**Consultation Response from KC,
Lead Local Flood Authority**

2023/93539 Land adj, Ledgard Bridge Mill, Back Station Road, Mirfield, WF14 8NZ

Date Responded: 1st March 2026

Escape Stair Section 1: 50

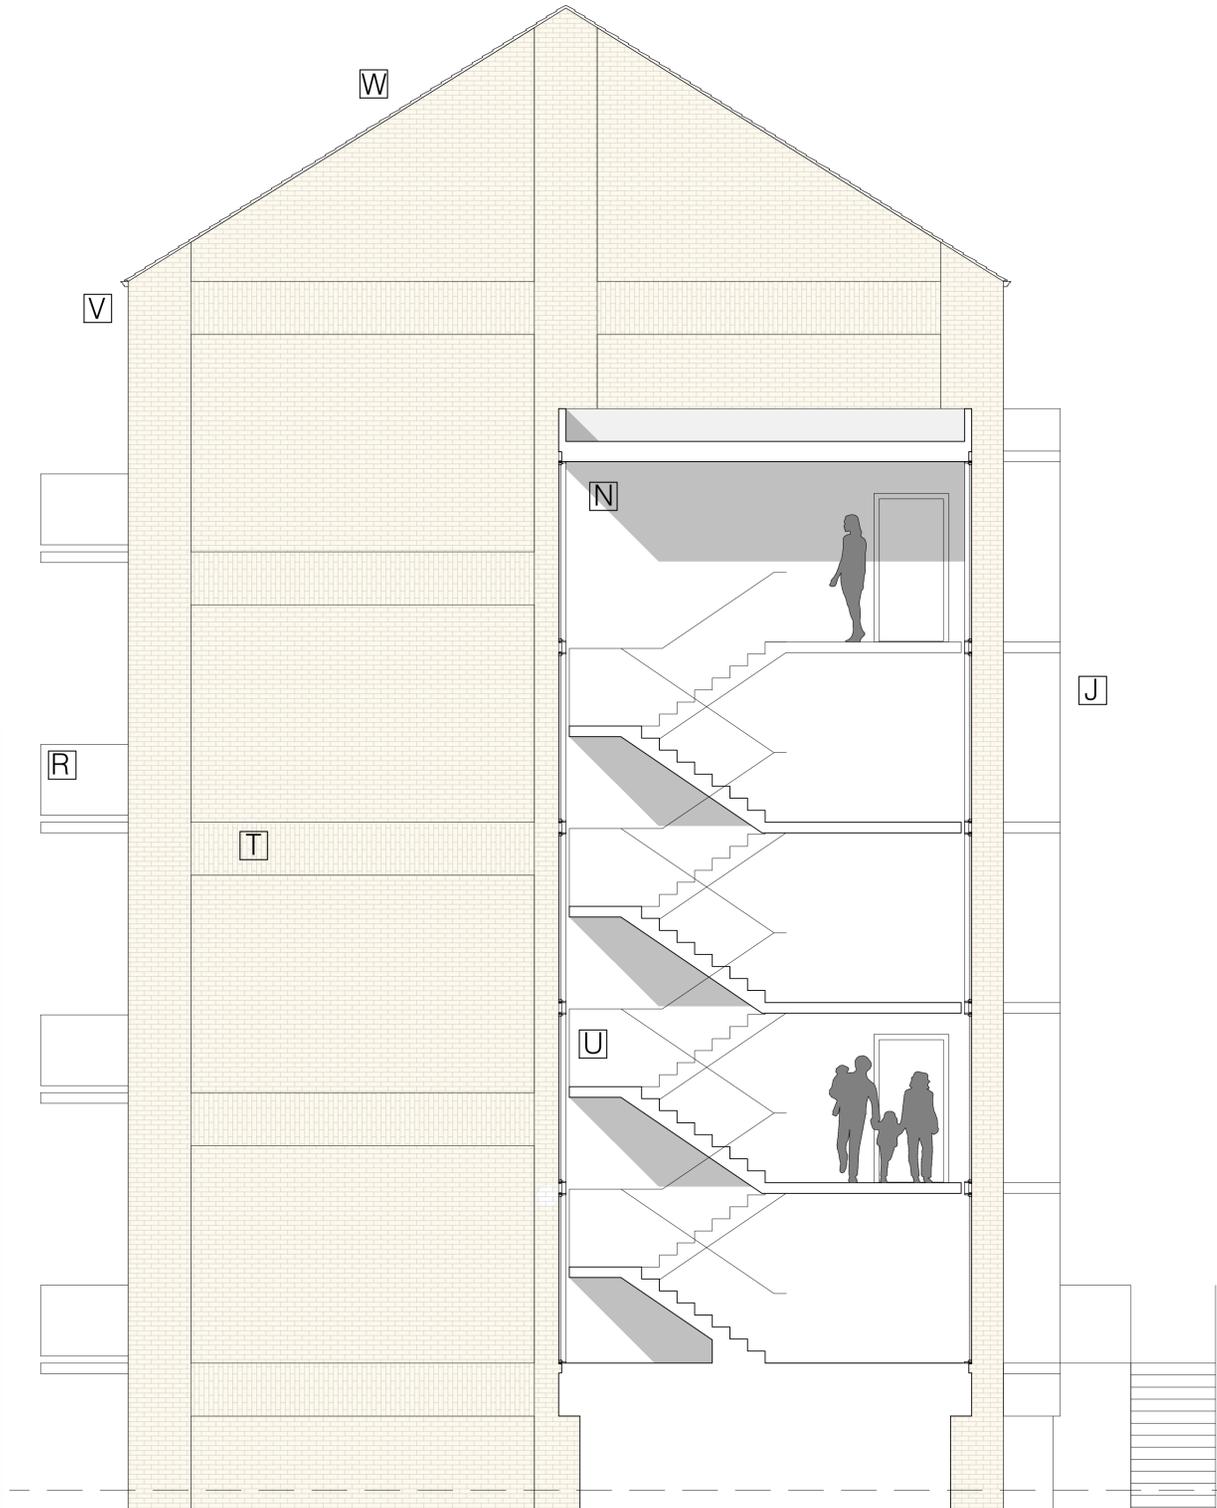
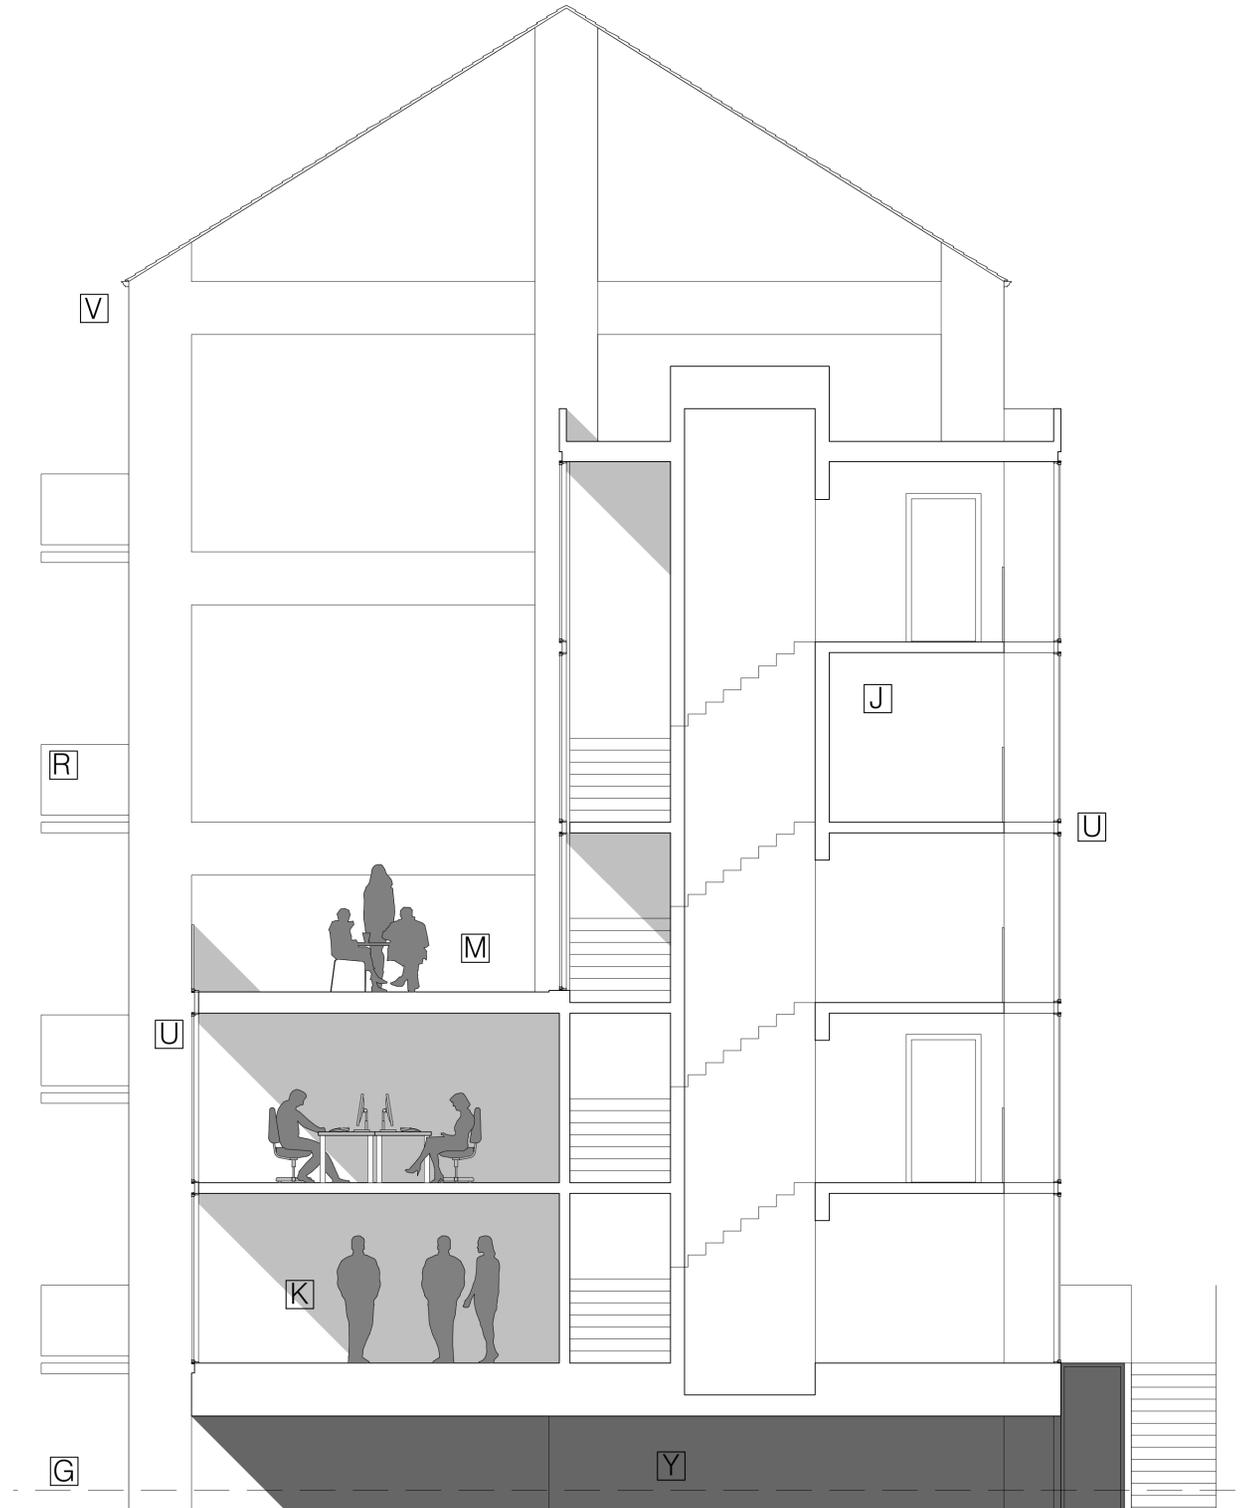
Plans provided now appear to show a level access to the emergency walkway that makes sense of any finalised evacuation process.

DR15 Flood Warning and Evacuation Plan/Emergency Walkway Design (SPECIAL)

Development shall not commence until a scheme detailing the provision of a flood warning system, arrangements for emergency access to the site and egress from the site to a place of safety (evacuation plans) for the construction and post development phases have been submitted to and approved in writing by the Local Planning Authority. The scheme shall include details of elevated dry walkways including how this structure is designed to withstand pressures and impacts associated with

flowing flood waters at depths associated with the 1 in 100 year + climate change event, and how it will not increase flood risk elsewhere. Details of how residents/tenants are to be informed of the procedures to follow in the event of receiving a flood warning or in the event of a flood. The evacuation plans shall be implemented in accordance with the accepted details prior to work commencing on site (for the construction phase) and prior to the occupation of the development (for the future residents) and be retained thereafter.
